**KIRKLEES METROPOLITAN COUNCIL
INVESTMENT & REGENERATION SERVICE**

Reference No:	2023/62/92198/E
Site Address:	47, Oddfellows Street, Scholes, Cleckheaton, BD19 6NX
Description:	Erection of first floor side extension
Recommending Officer:	Katie Wilson

HOUSEHOLDER DELEGATED REPORT

Application Number	2023/92198
Location	47, Oddfellows Street, Scholes, Cleckheaton, BD19 6NX
Proposal	Erection of first floor side extension
Publicity end date	19 th October 2023
Number of representations received	None
Kirklees Local Plan Allocation/Designation	Unallocated
Extension to Time (EoT)	Yes EoT Date: 6 th February 2024
Recommendation	Conditional Full Permission

first floor

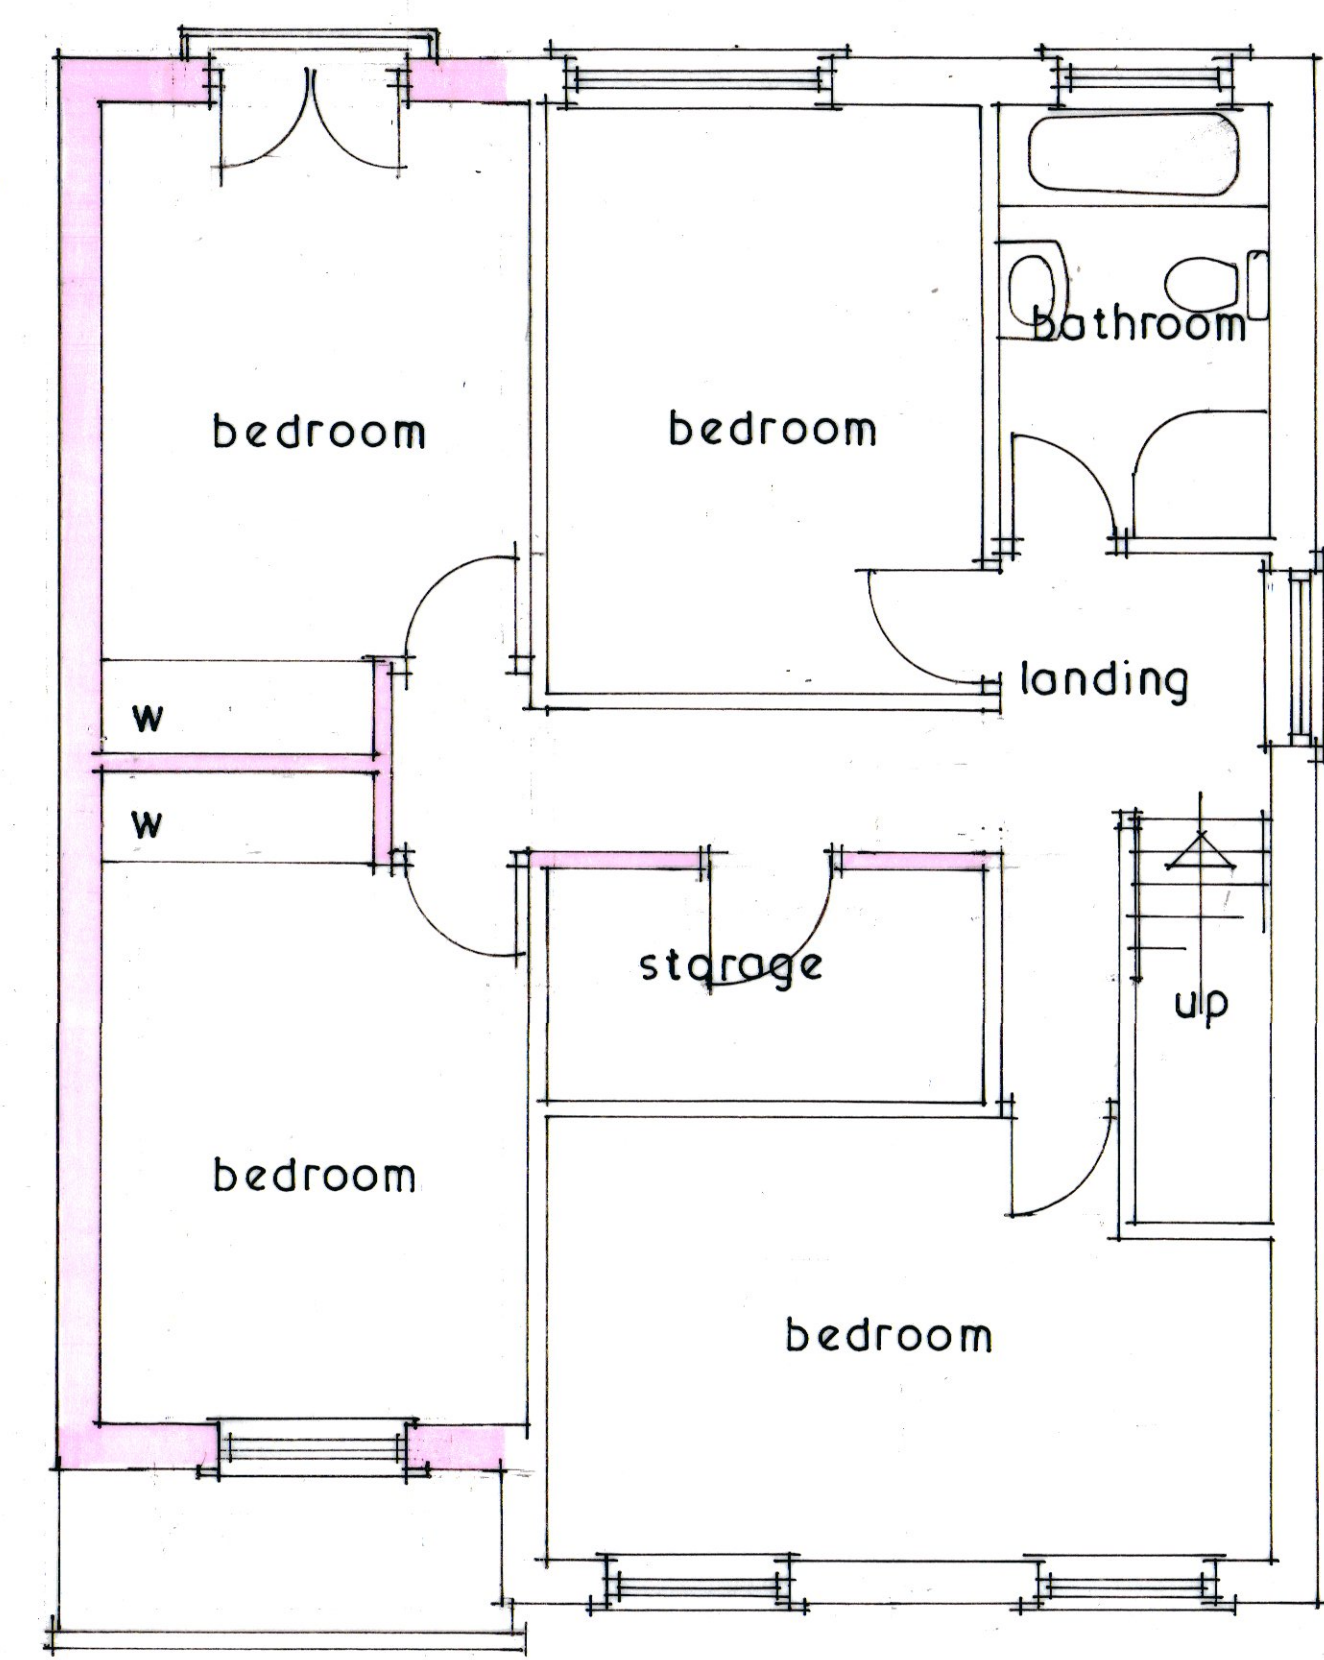
properties in the same row. Most of the others have first floor side extensions of various designs. These mitigating circumstances are sufficient to provide justification for not complying with this criteria.
Maintain a 1 metre gap to the side boundary to ensure the building is not too close to a neighbouring property		No. For the same reasons as above, it is considered that there are sufficient mitigating factors to justify non compliance with this criteria.
Be set back at least 500mm from the front wall of the house.	Yes. The first floor element would be set back approximately 1.0m from the front elevation.

Roof style	• KDP 1 and 2 of the SPD • Policy LP24 Design (a), (c) and (d) of the KLP • Chapter 12 of the NPPF	It would have a dual pitched roof which is in keeping with that on the original part of the house. The angle of pitch would be lower, but nevertheless this is considered not to detract from the appearance of the host dwellinghouse, and is acceptable in terms of KDP 1 and 2 of the SPD and policy LP24 of the KLP.	✓
Window proportions	• KDP 1 and 2 of the SPD • Policy LP24 Design (a), (c) and (d) of the KLP • Chapter 12 of the NPPF	The proposed window on the front elevation would match those on the host dwellinghouse. On the rear elevation would be set of patio doors and Juliet balcony. This would replicate to some extent the bi-folding doors at ground floor level in the rear elevation. Whilst it is unknown if the existing bi-folding doors are original features, it is nevertheless thought that the Juliet balcony feature would be inkeeping with the domestic appearance of the building.	✓

Relevant key design principle (KDP) of the SPD, Policy in the Kirklees Local Plan and the NPPF	Further comments	✓ / X / N/A
Impact on privacy of neighbours.	• KDP 3 & 4 of the SPD • Policy LP24 Design (d) (iv) • Chapter 12 of the NPPF	In this instance the proposed extension would be very close to the boundary with 45, Oddfellows Street and have no openings in its side elevation. The facing side elevation at 45, Oddfellows Street contains one door and small window at ground floor with one other small window at first floor level to a landing. There would be a separation distance of around 3.0m. The new first floor includes habitable accommodation that would have a view to the rear. As the existing first floor includes windows it is not considered that the proposed will result in a loss of privacy over and above the existing relationship. Provided permitted development rights are removed for new openings in the side of the proposed first floor	✓

extension, the proposal is considered to comply with KDP3 & 4 of the SPD and policy LP24 of the KLP.	
Impact on light and outlook of neighbours	• KDP 4, 5, 6 of the SPD • Policy LP24 Design (b) • Chapter 12 of the NPPF	The additional massing of the proposed first floor side extension would have potential to cast additional shade particularly in the first half of the day. However, this would be mainly over the side eastern side of the house and external walkway. Much of the front and rear outdoor amenity space would be unaffected. Whilst the footprint of the houses in this row are slightly staggered, it is considered that this would not have a significant impact upon the outlook from 45, Oddfellows Street. The main windows to this neighbouring property look directly out onto the front and rear gardens and in officer's opinion would be largely unaffected by the proposed extension. As such it is considered to be compliant with KDP 4, 5, & 6 of the SPD. It would accord with policy LP24 of the KLP.	✓

4. Notwithstanding the provisions of the Town and Country Planning (General Permitted Development) (England) Order 2015 (as amended), or any subsequent legislation revoking or superseding that Order, no windows, doors or other openings, other than those shown on the approved plans, shall, at any time, be formed within the west facing side elevation of the approved first floor side extension.
